Mark Dorsey
First Lamp Architecture
4915 S Rainier Ave S Ste 202
Seattle, WA 98118

Subject: Response letter for 2304-194 / DSR23-003 plan comments dated May 10th, 2023.

Summary of drawing changes

INTERIOR ELEVATIONS

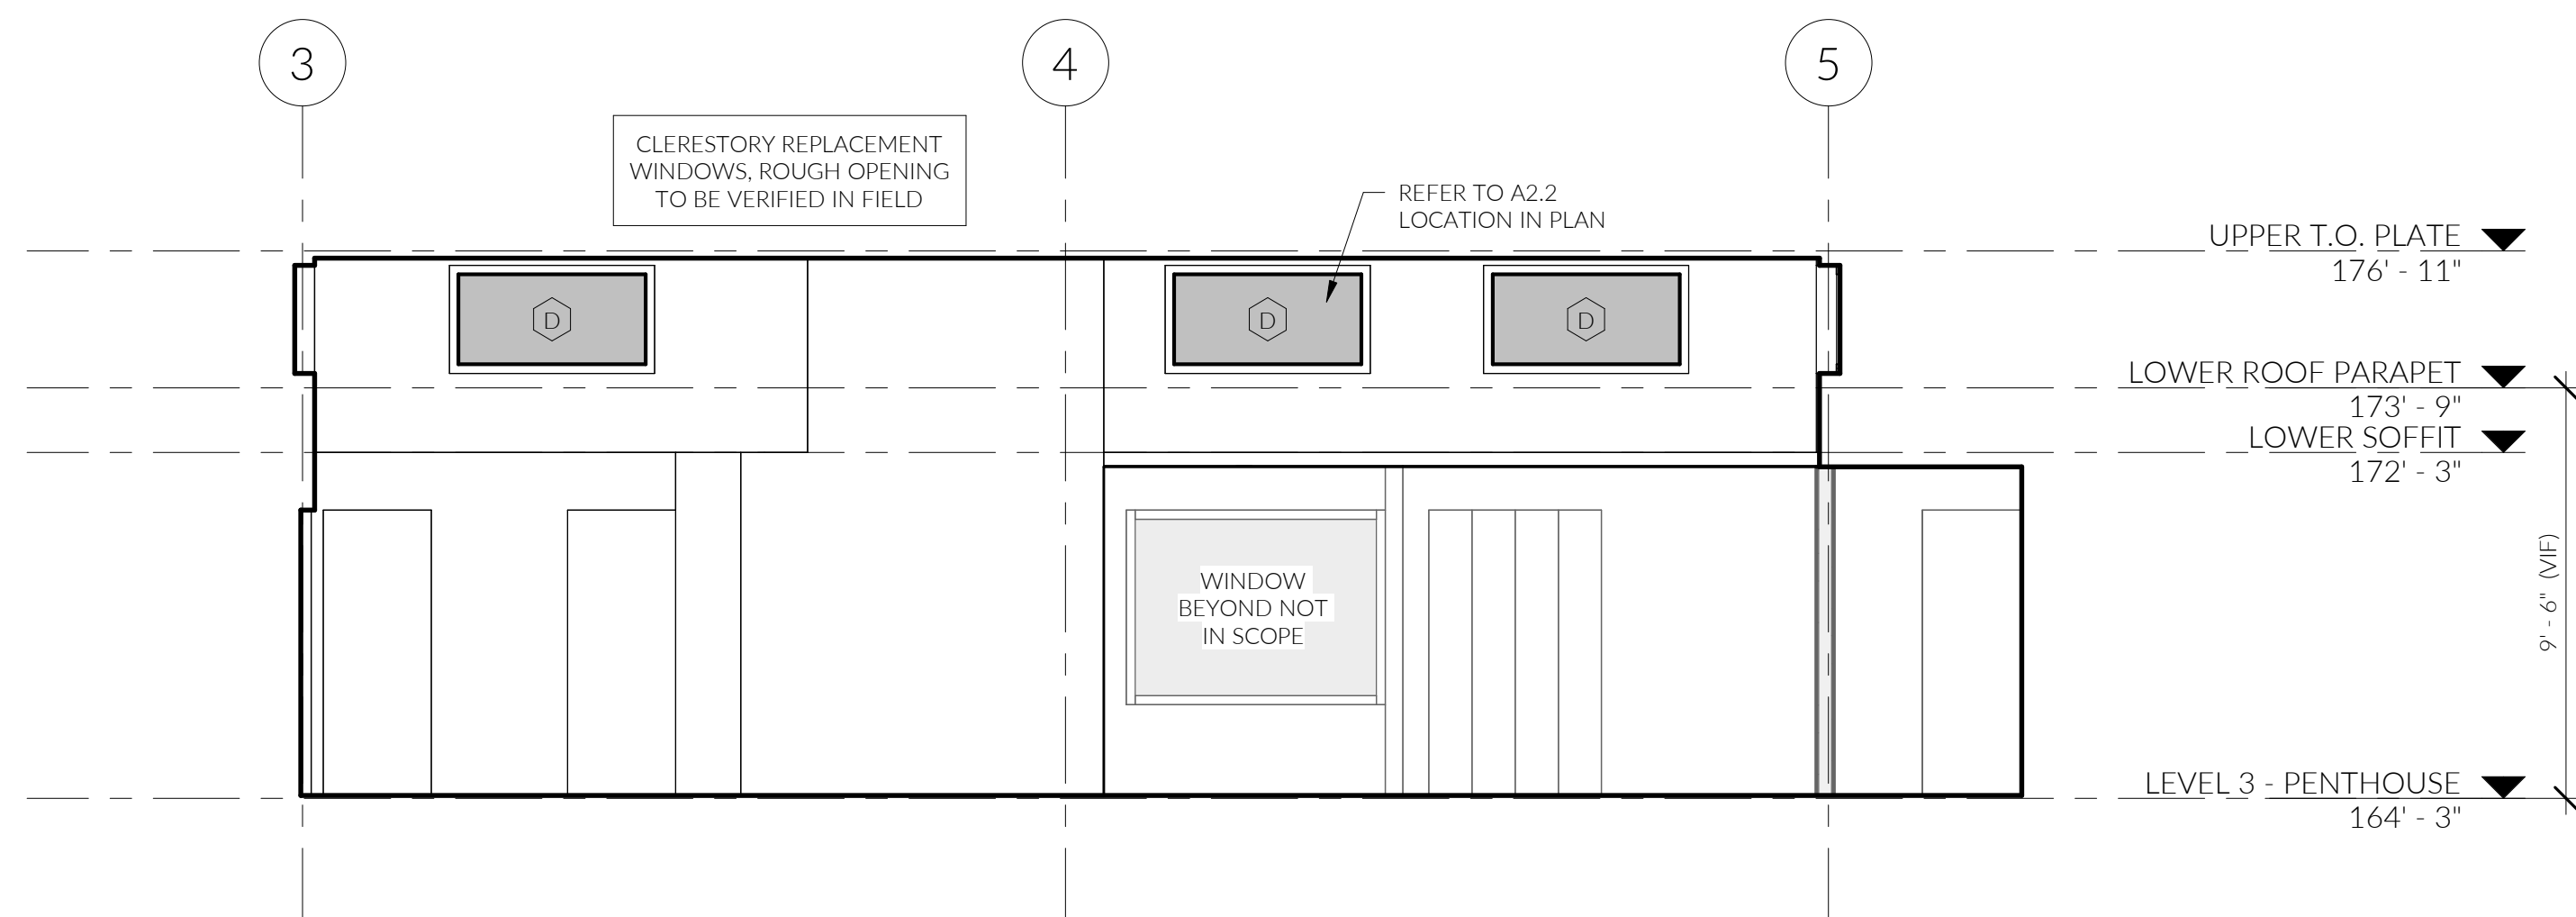
A6.0 - INTERIOR ELEVATIONS

Adjusted vertical mullion spacing at East facing windows between gridlines 3 & 5. Added horizontal mullion break to align with existing clerestory windows.
